**Re: Constantine Short Plat
8817 SE 44th Street
SUB20-004**

Please consider this as a written response to the City of Mercer Island first review comments dated February 2, 2021.

*From City of Mercer Island
SUB20-004 First Review Comments
2/2/2021*

BT-01
SHEET 2 OF 7

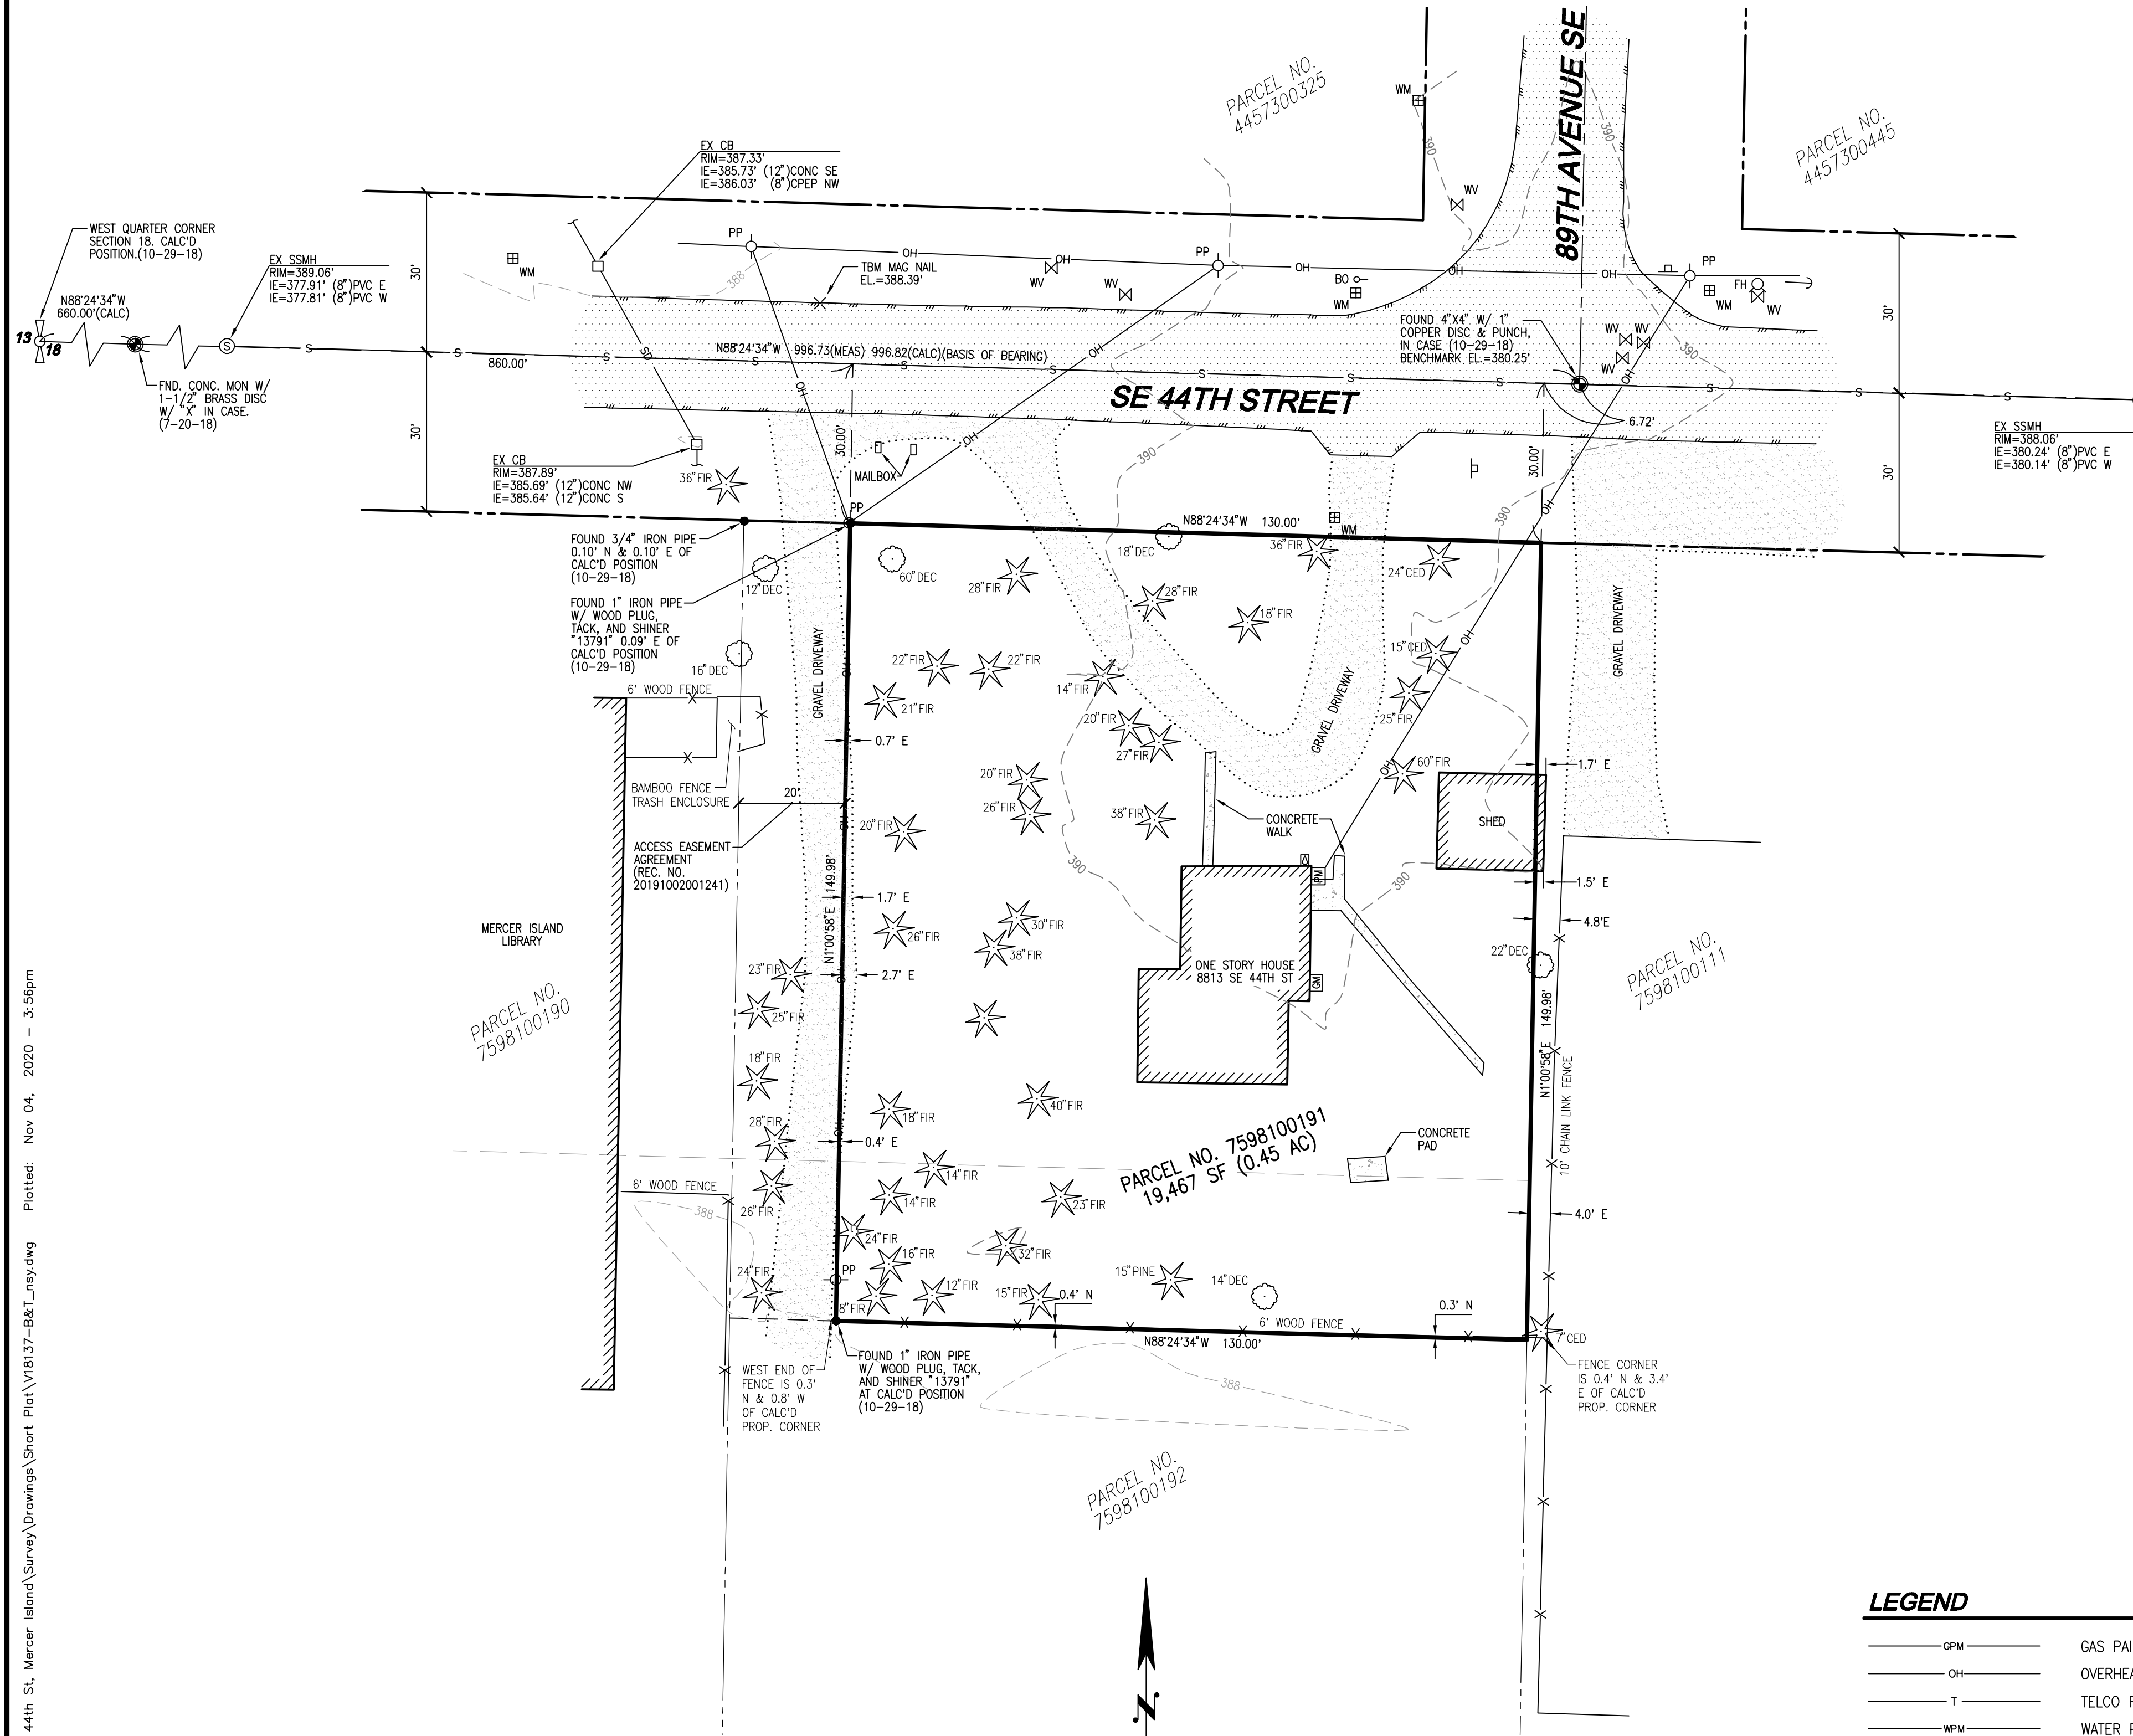
21. *Topography map: for any existing buildings, the map shall show the finished floor elevations of each floor of the building. The information requested has been called out on Civil plan sheet 2.*
22. *Indicate compliance with MICC 19.09.040 private access roads and driveways. The shared access driveway along the west side of the project has been revised to comply with MICC 19.09.040.*

DRAWN BY: NSY	DATE: 28 OCT 20	DRAWING FILE NAME: V18-137-SP	SCALE: N.T.S	JOB NUMBER: V20-137	SHEET: 4 OF 7
---------------	-----------------	-------------------------------	--------------	---------------------	---------------

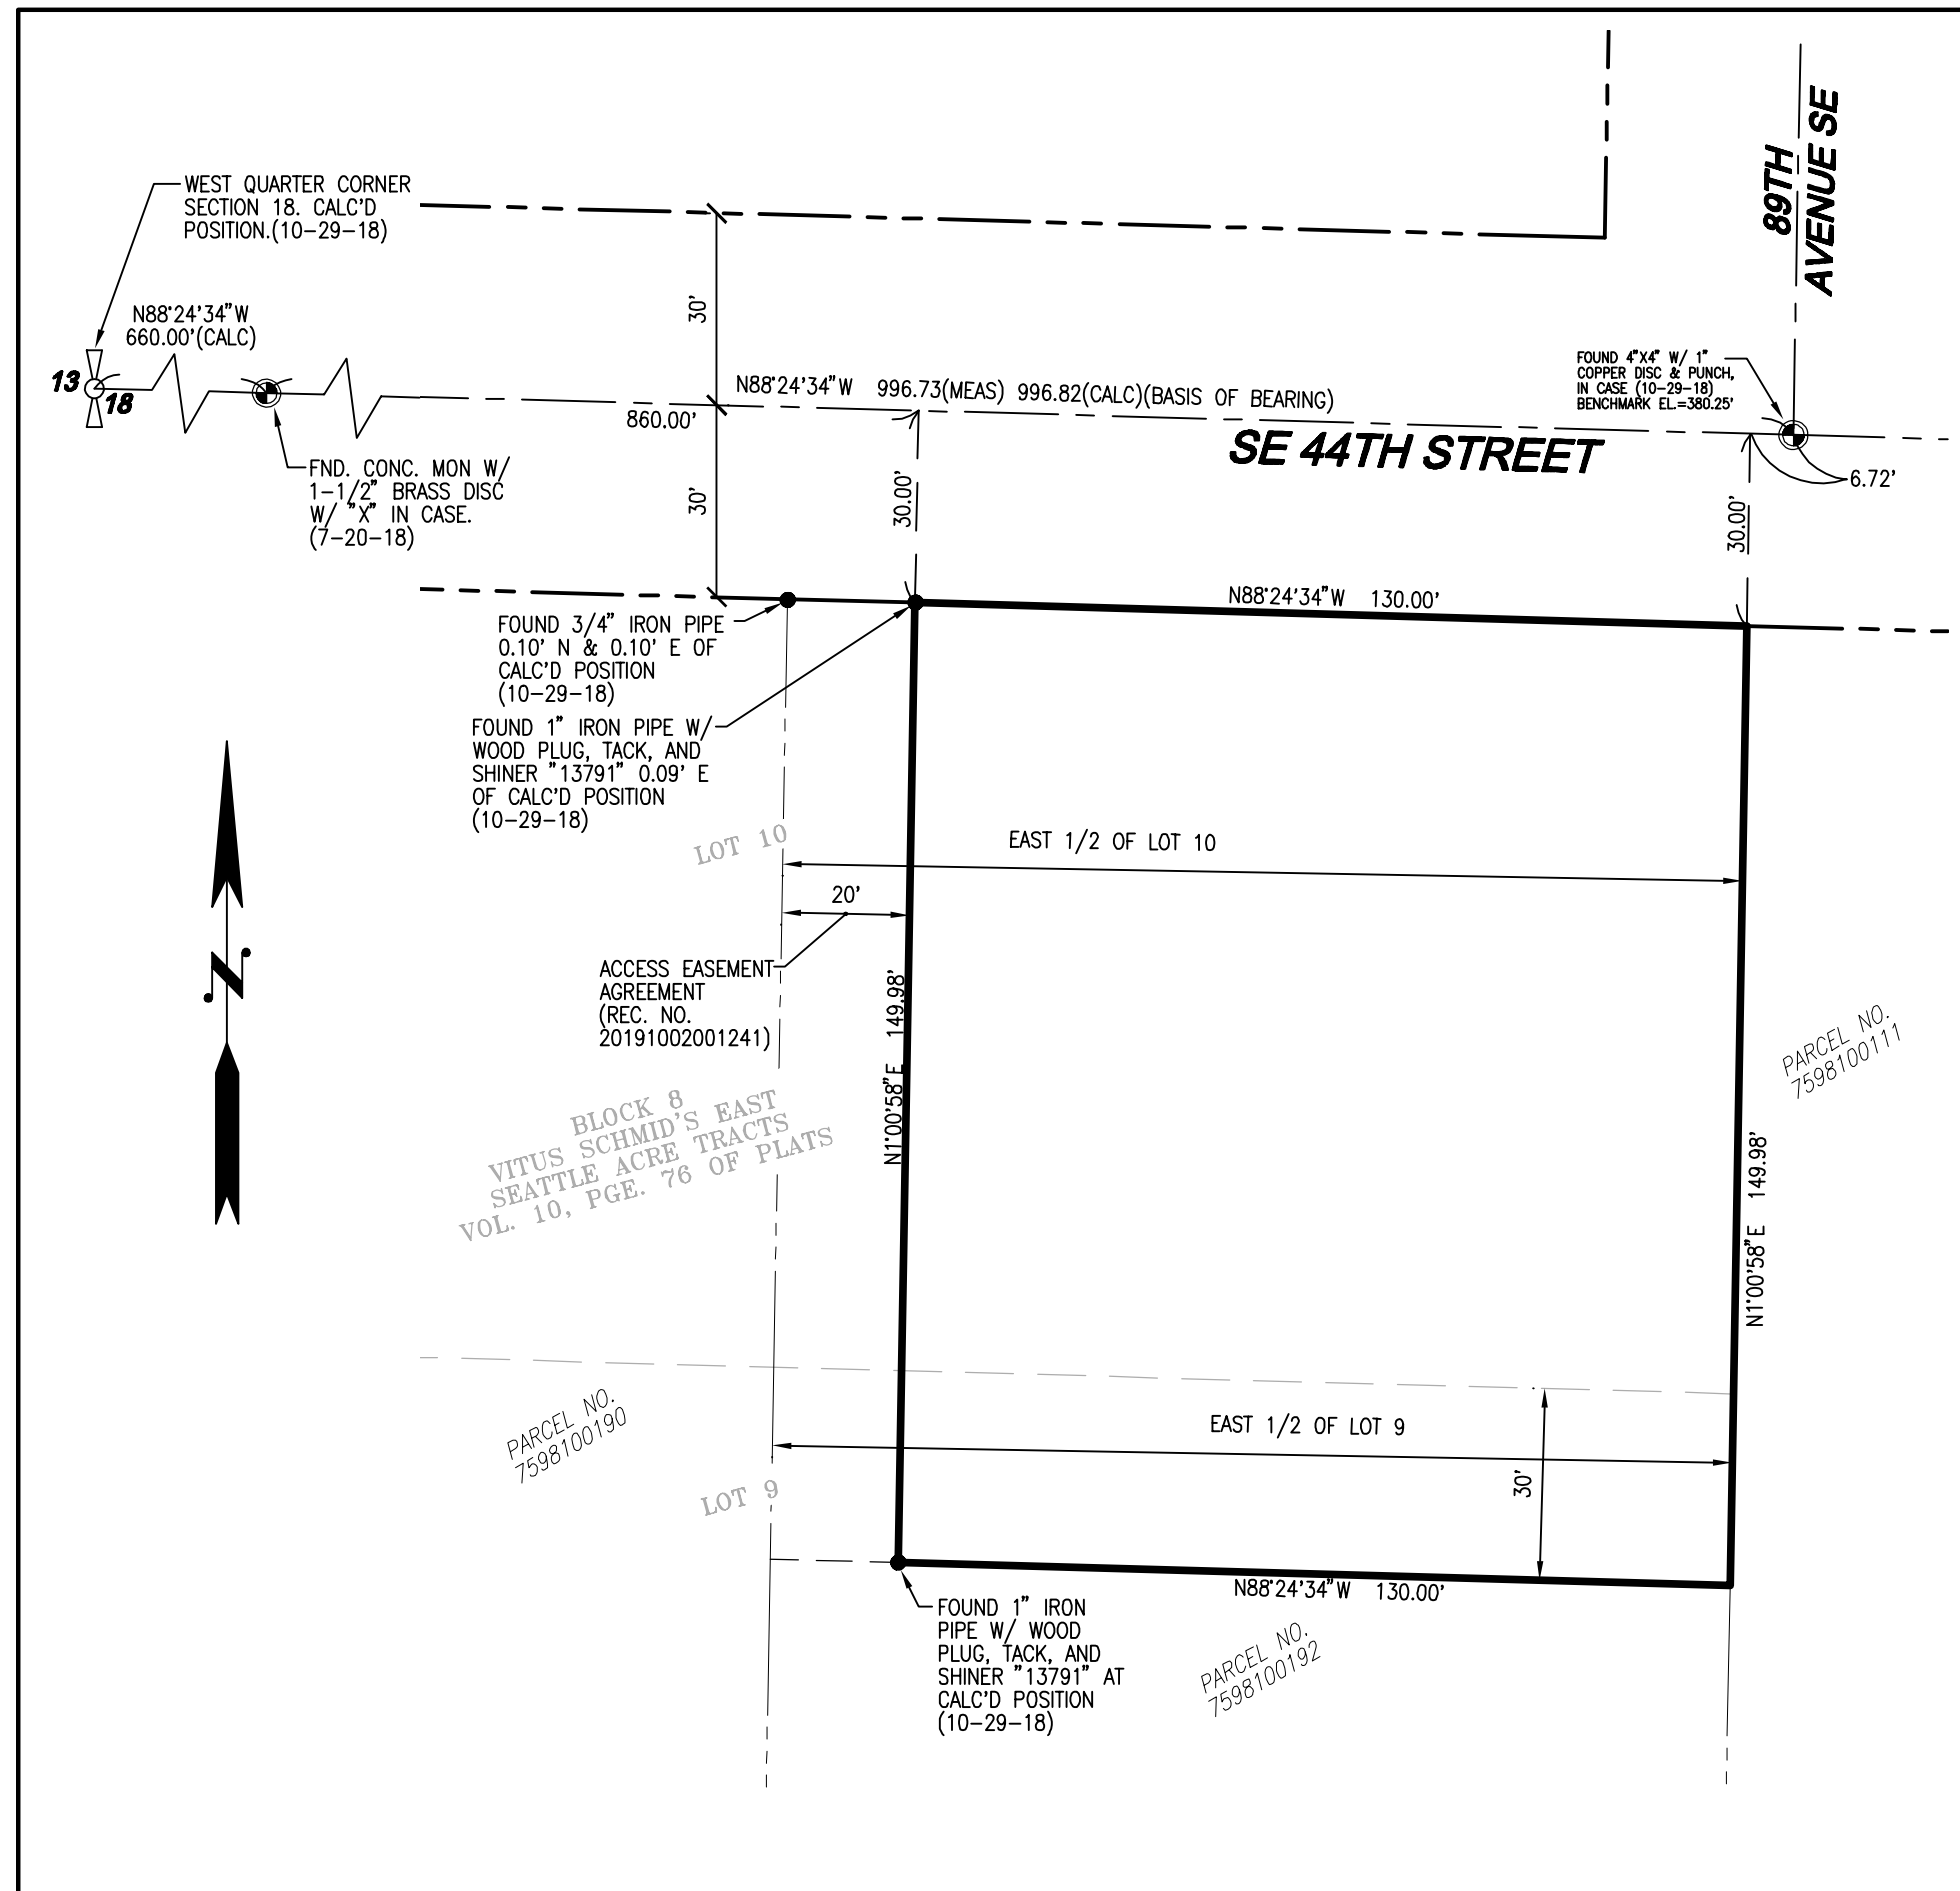
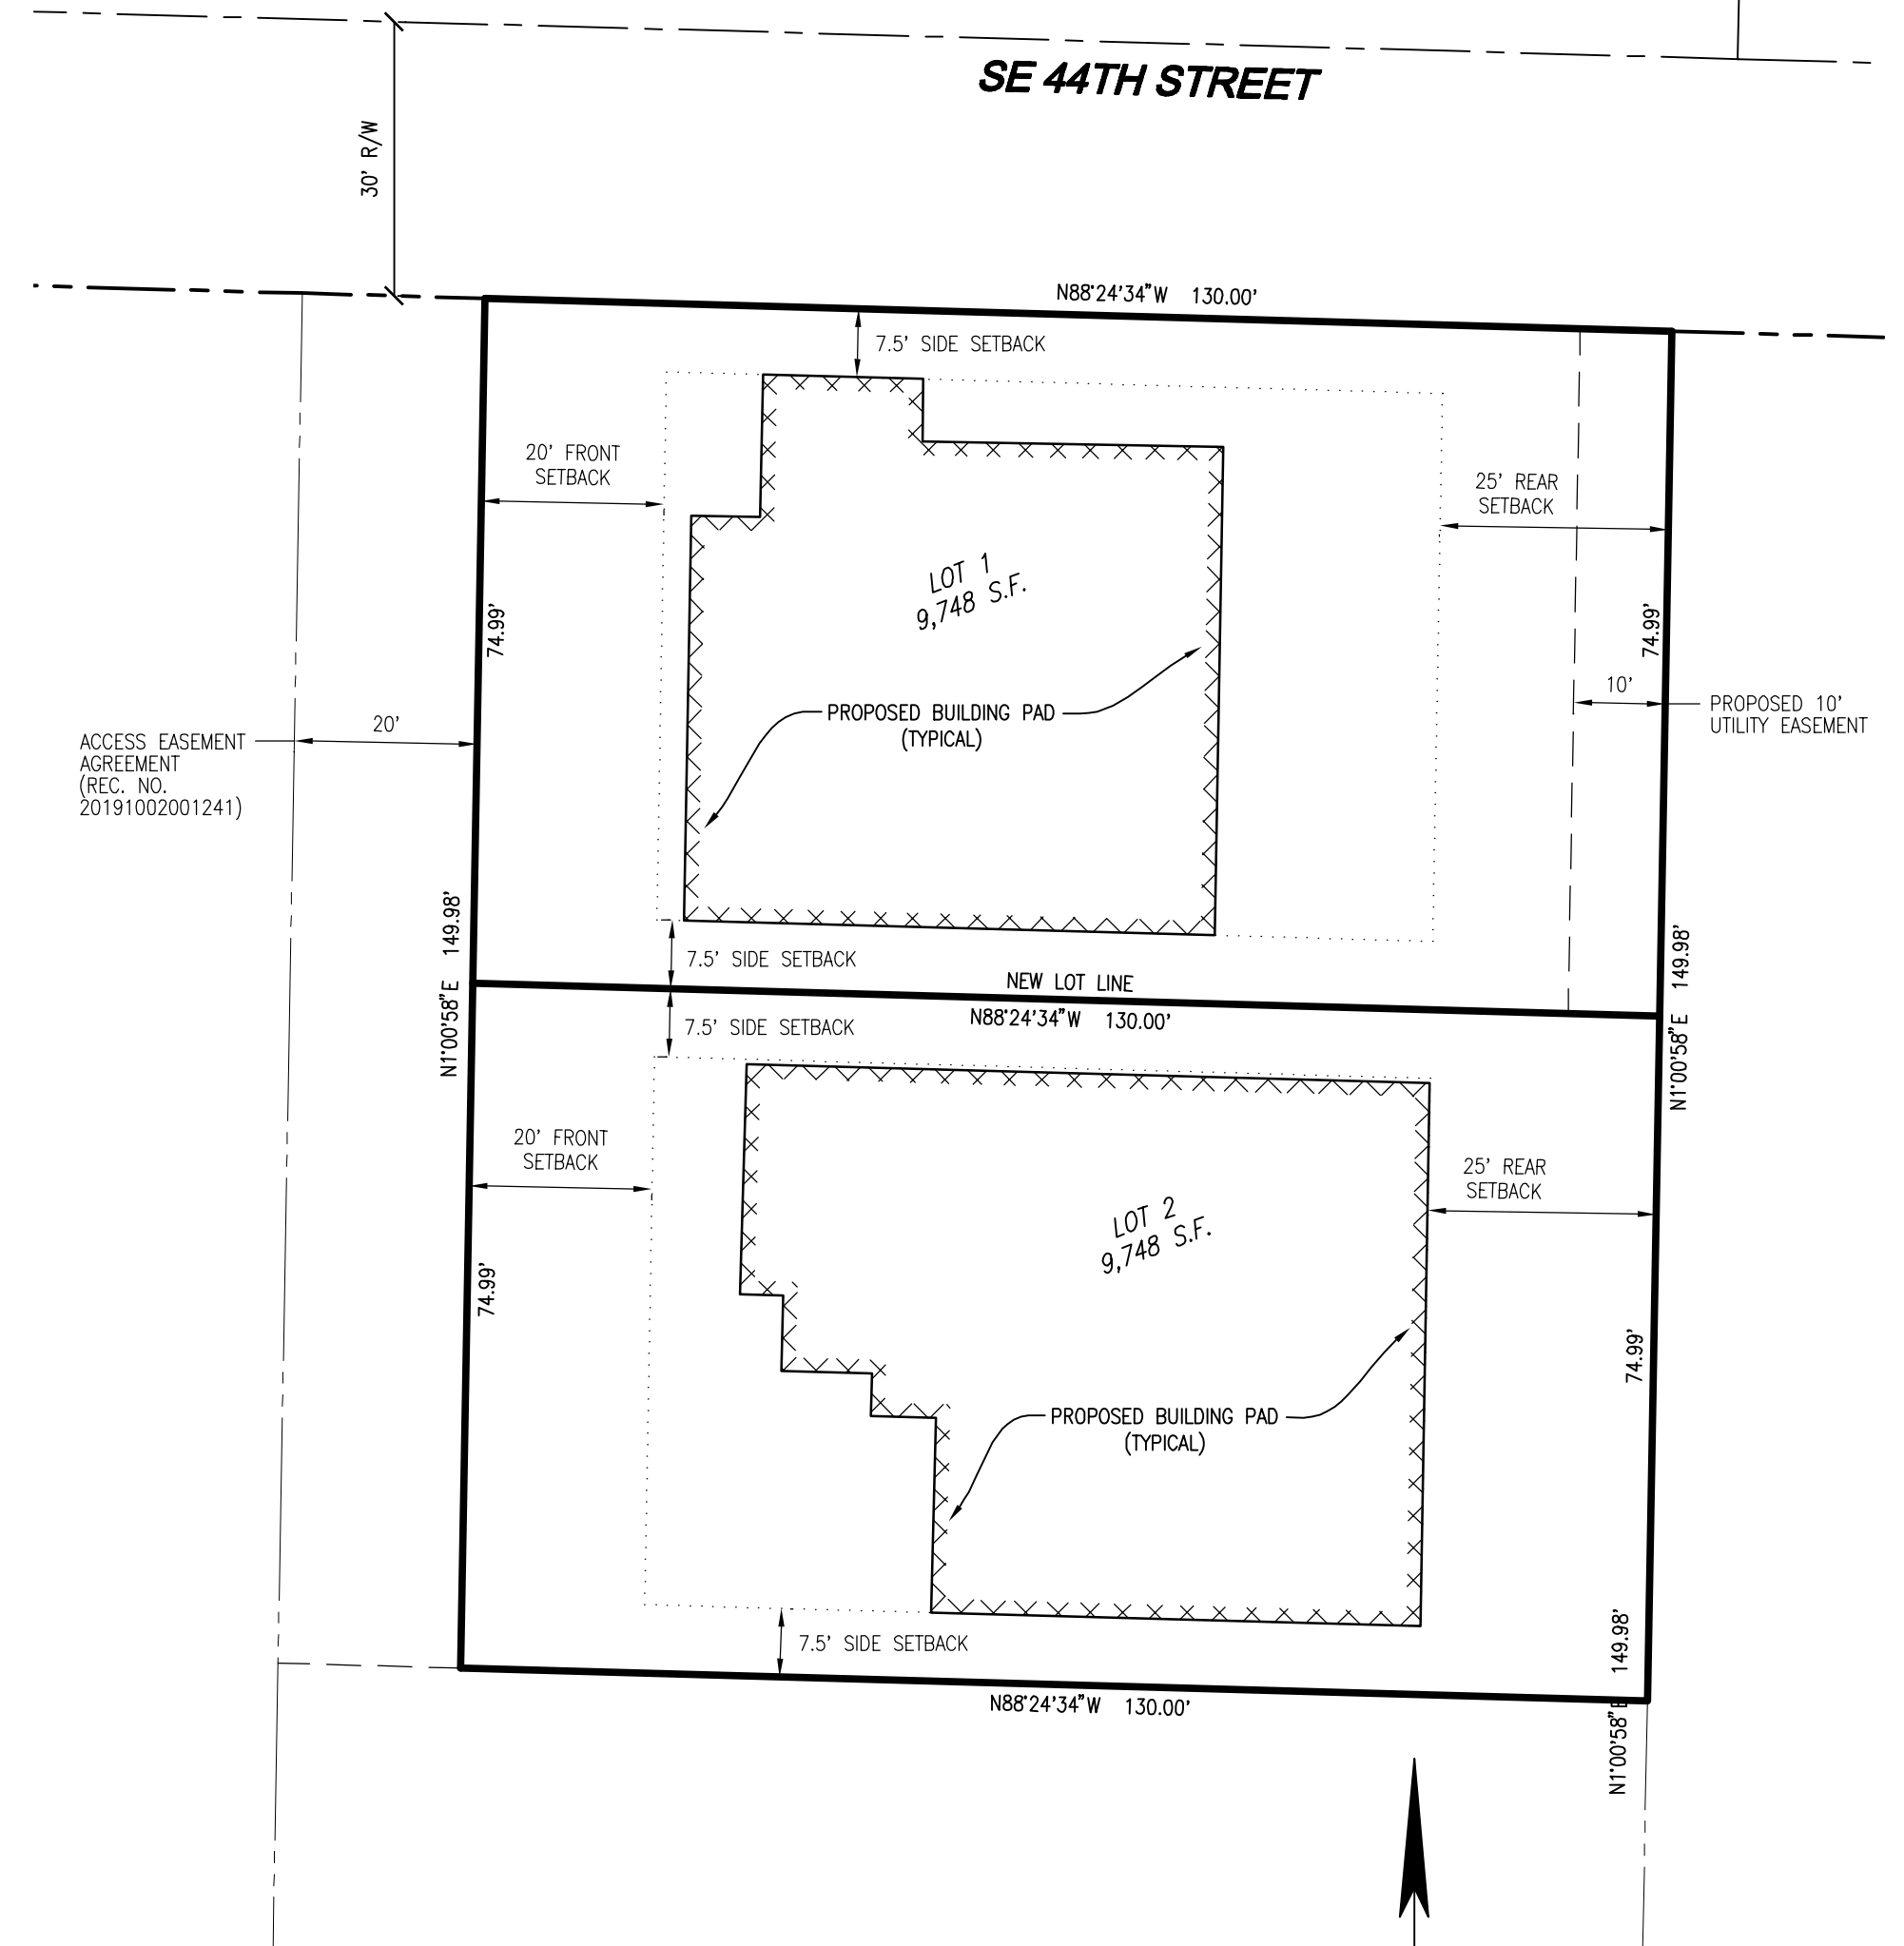
18. *Please also add the approval note to sheet 3 of 7: "This request does not guarantee that the lots will be suitable for development now or in the future. The legal transfer of the property must be done by separate instrument unless all lots herein are under the same ownership." The note has been added and to sheet 1 of 10.*
